KITITAS COUNTY

MEMORANDUM

TO: All Staff
FROM: Public Works Plan Review Team
DATE: November 4, 2021
SUBJECT: LP-21-00003 Stanavich Plat

STANAVICH AG PLAT  
PART OF SECTION 35, T. 19 N., R. 18 E., W.M.  
KITITAS COUNTY, WASHINGTON  
- PRELIMINARY PLAT -

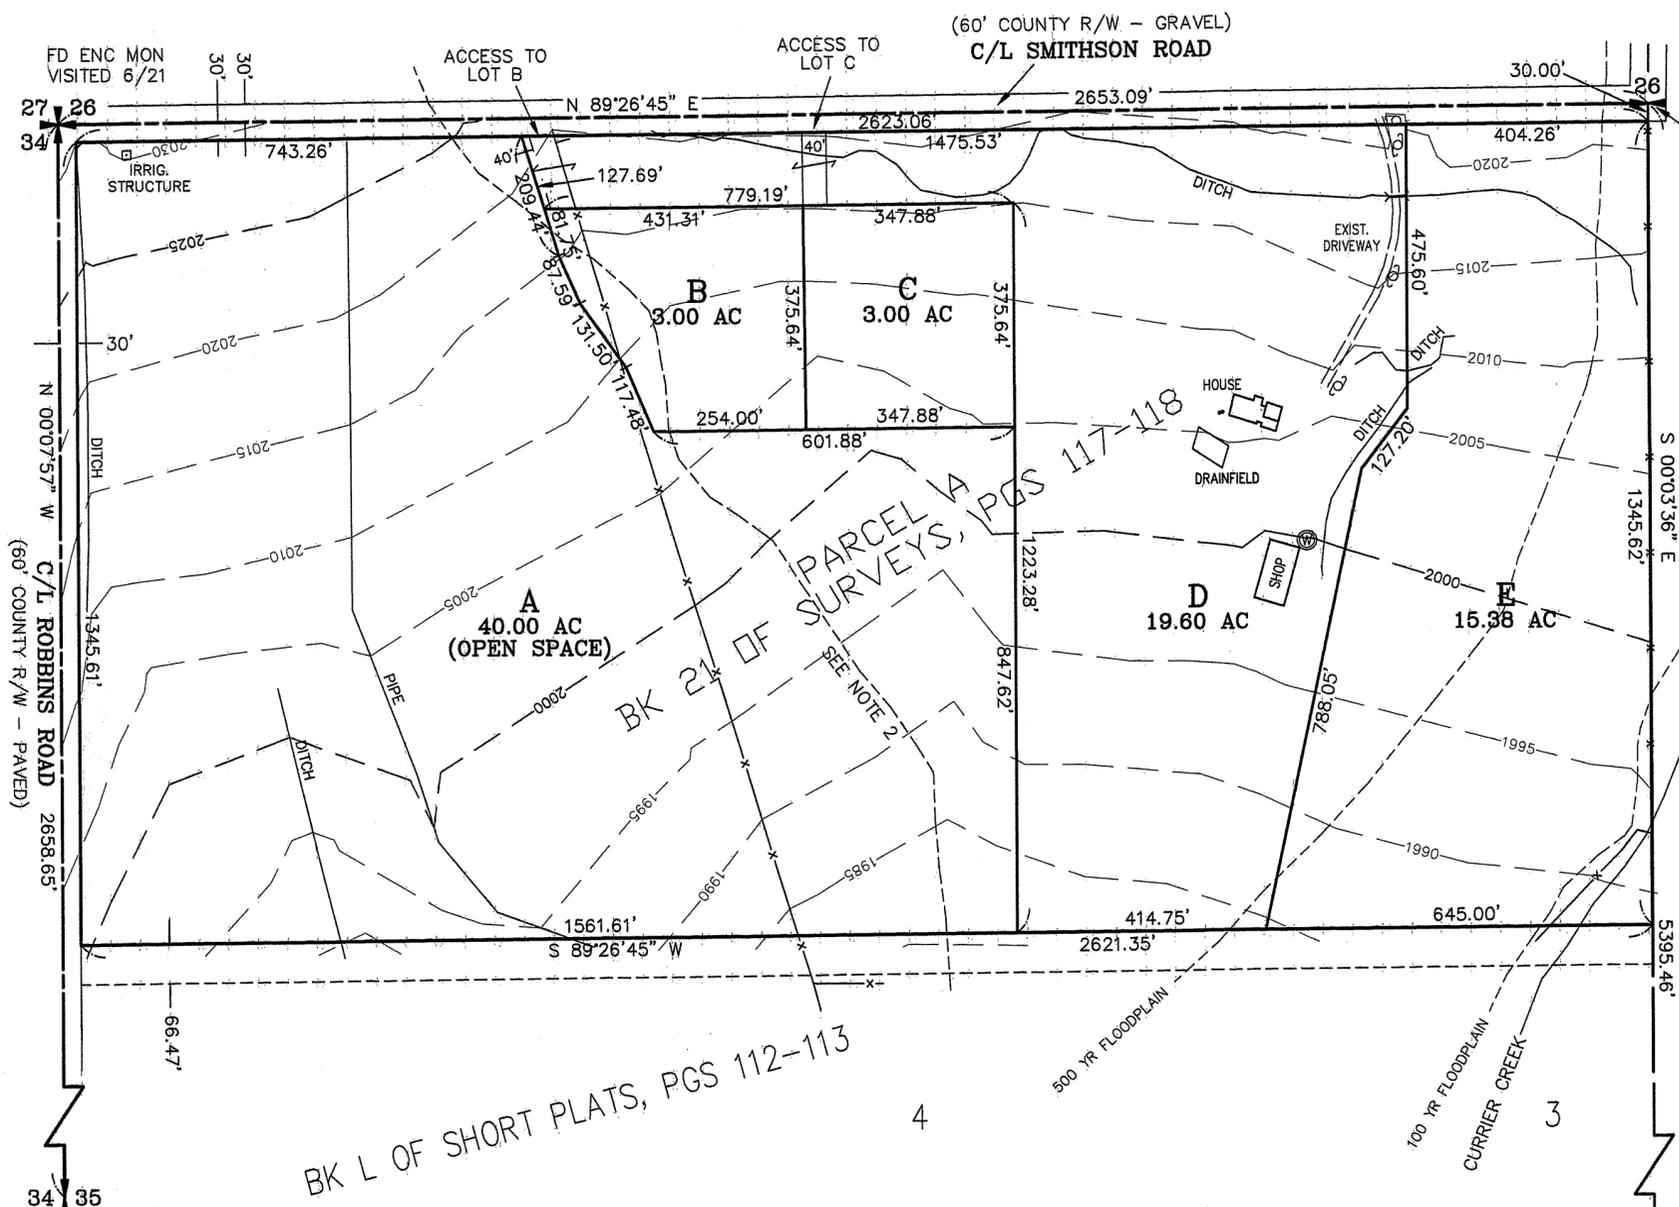
1. To limit the number of accesses onto the county road system, the plat must serve lots B&C and D&E from joint-use driveways.

Direct access from an individual lot to the County Road shall not be permitted unless no other alternative exists. Newly created lots shall access onto an internal road system and not directly onto a County Road, unless approved by the County Engineer. Lots adjoining County Roads shall access from the lowest classified road or from a joint-use driveway, when possible. Police, fire, ambulance, and other emergency stations shall have a right to direct access to County roads.
